From: [Irene Martin](#)
To: [Ania Dorocinska](#)
Subject: RE: Notice of Exhibition for Baiada Oakburn Poultry Processing Plant (SSD-9394)
Date: Tuesday, 30 July 2019 12:25:39 PM

I refer to the EIS for the Oakburn Poultry Processing Plant in Tamworth dated 2 July 2019 and undertaken by PSA Consulting Australia. To enable the Department's Hazards Team to finalise its review and assessment of the EIS, further detail and or clarification is required of the dangerous goods listed throughout the EIS:

BAIADA PTY LTD OAKBURN RENDERING PLANT 1154 GUNNEDAH ROAD, WESTDALE LOT 100 DP 1097471 — WASTE WATER TREATMENT PLANT CAL EARTHWORKS (DA 2018-0443) CAL LAYOUT PLAN	Ref. No: 17426-CAL Sheet No: 100 of 06 Revision: F © Bath Stewart Associates Pty Ltd

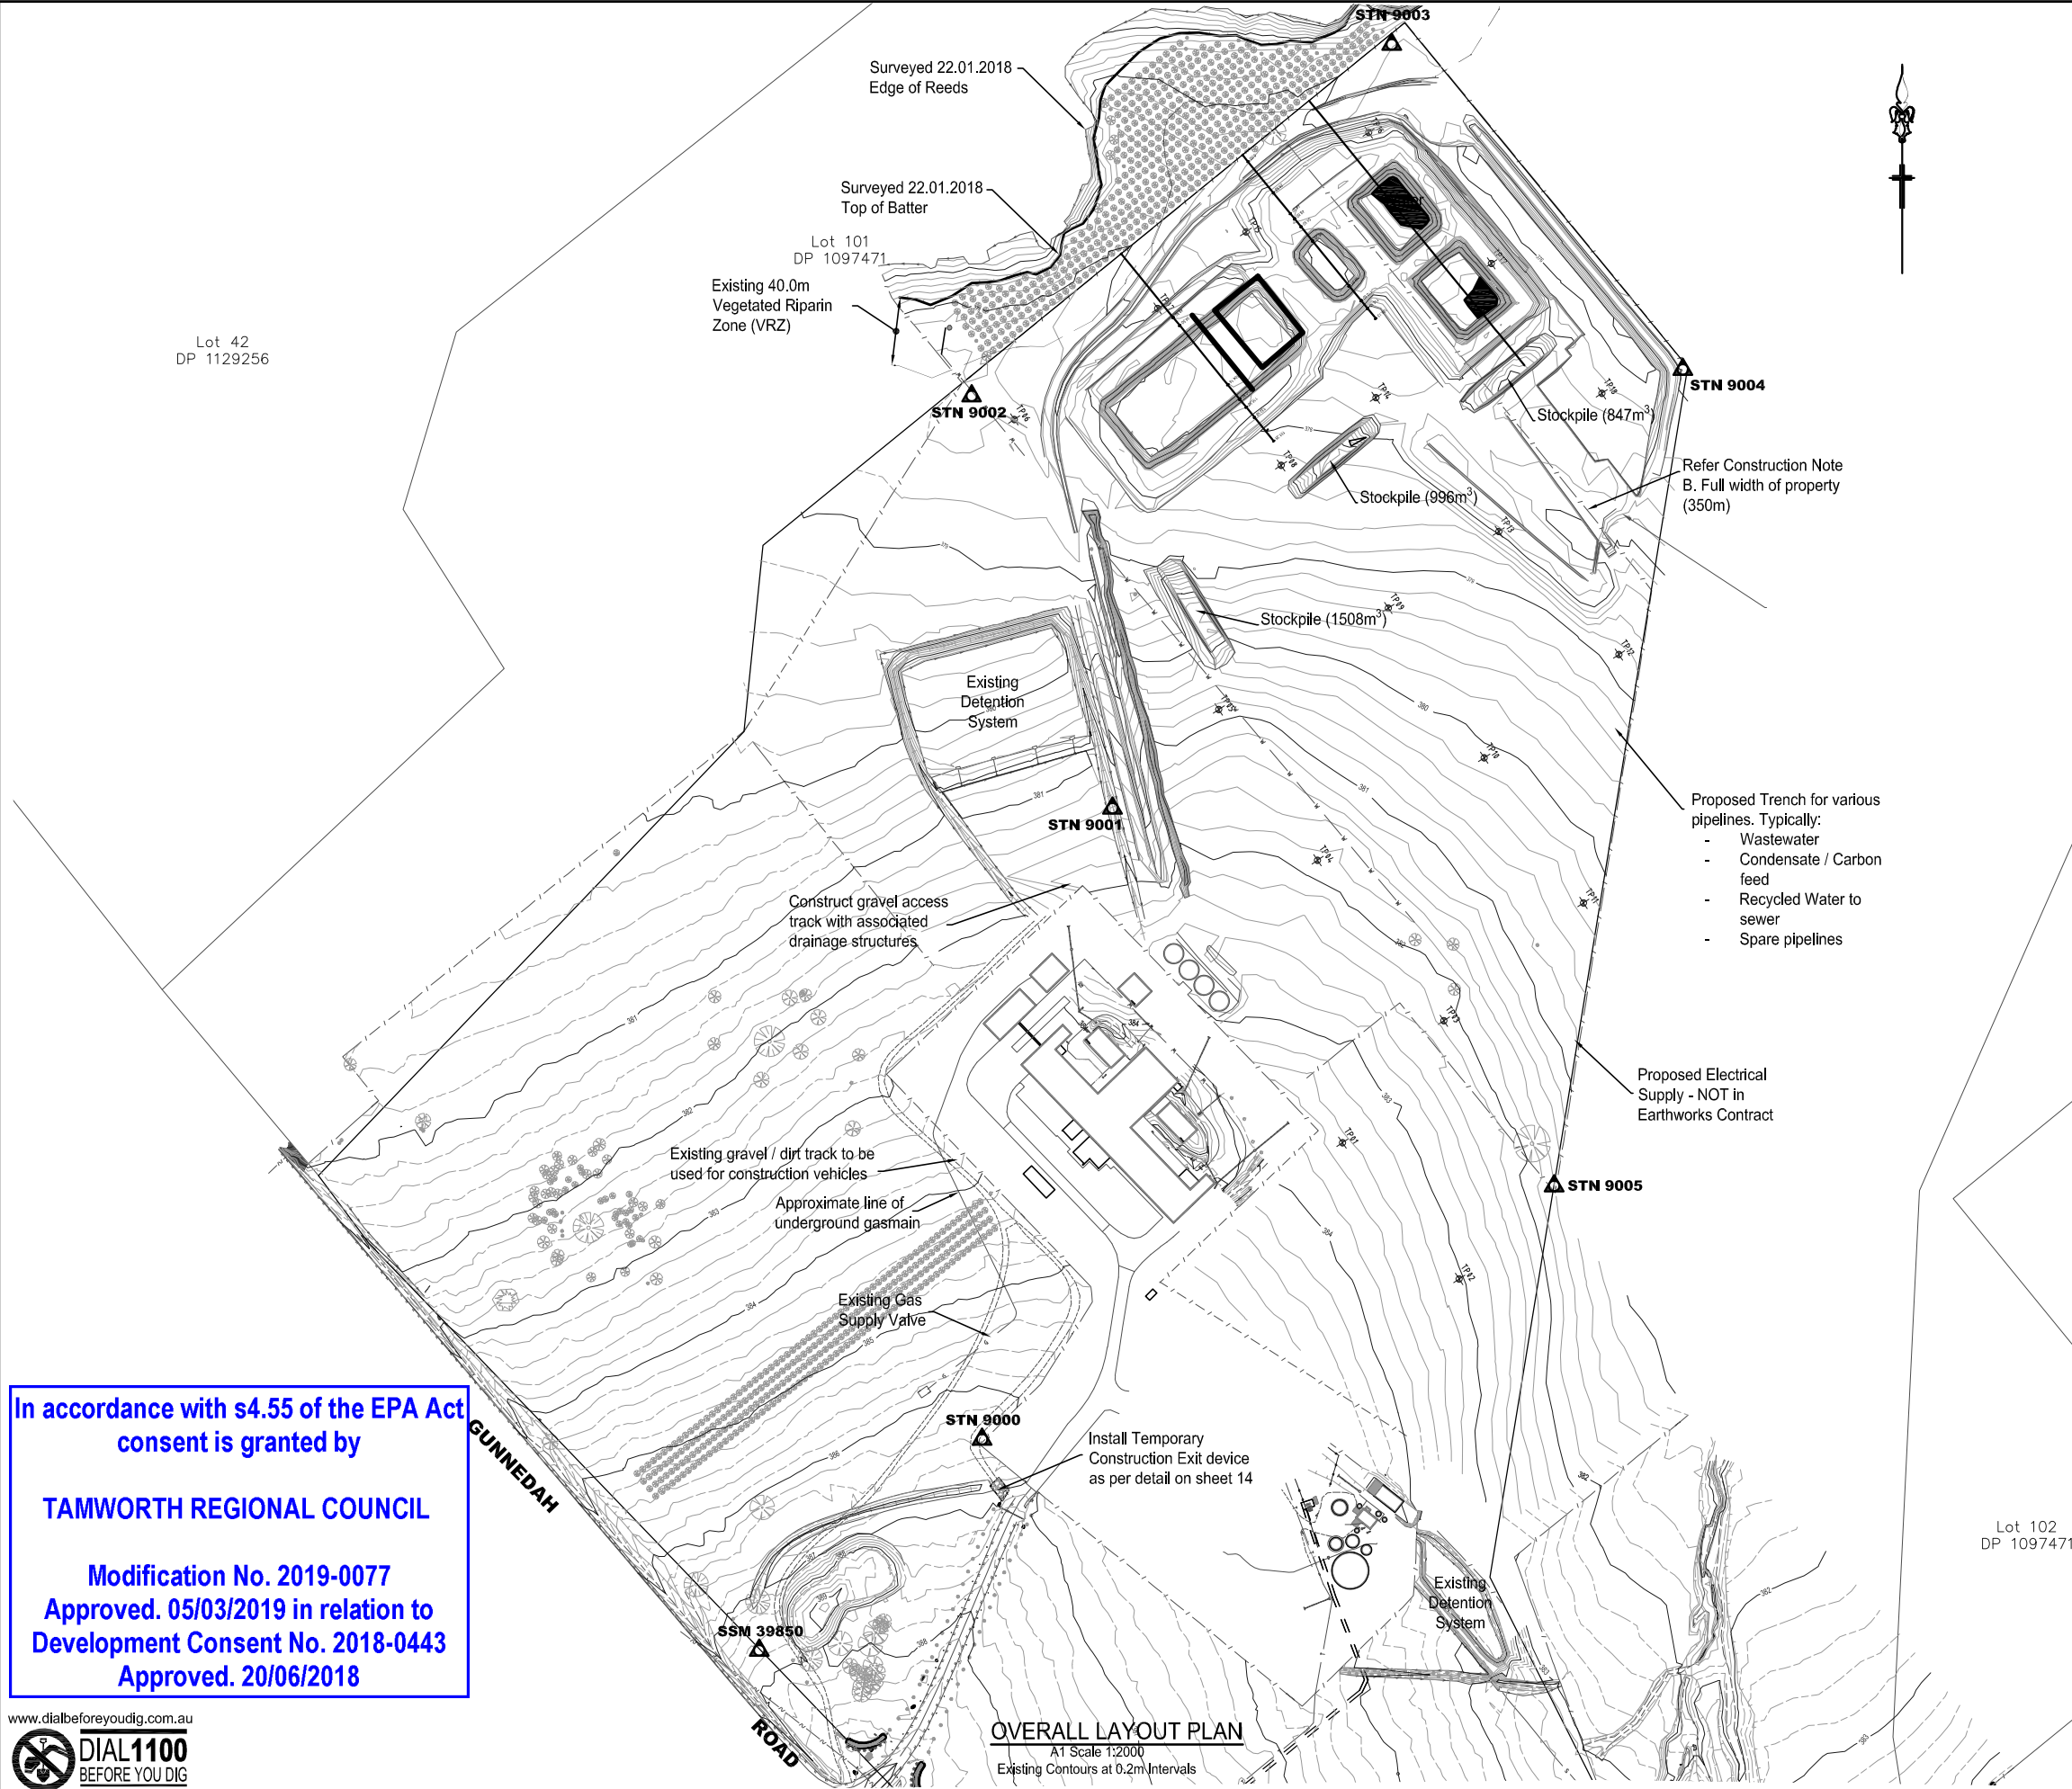
4. Is the new processing plant to be built over an existing Gas Supply Valve and underground gas main, refer to approved 20/06/2018 Tamworth Regional Council drawing number 17426-CAL Rev 7 for the Baiada Oakburn Rendering Plant? If not please indicate relocation of gas line and gas supply valve.
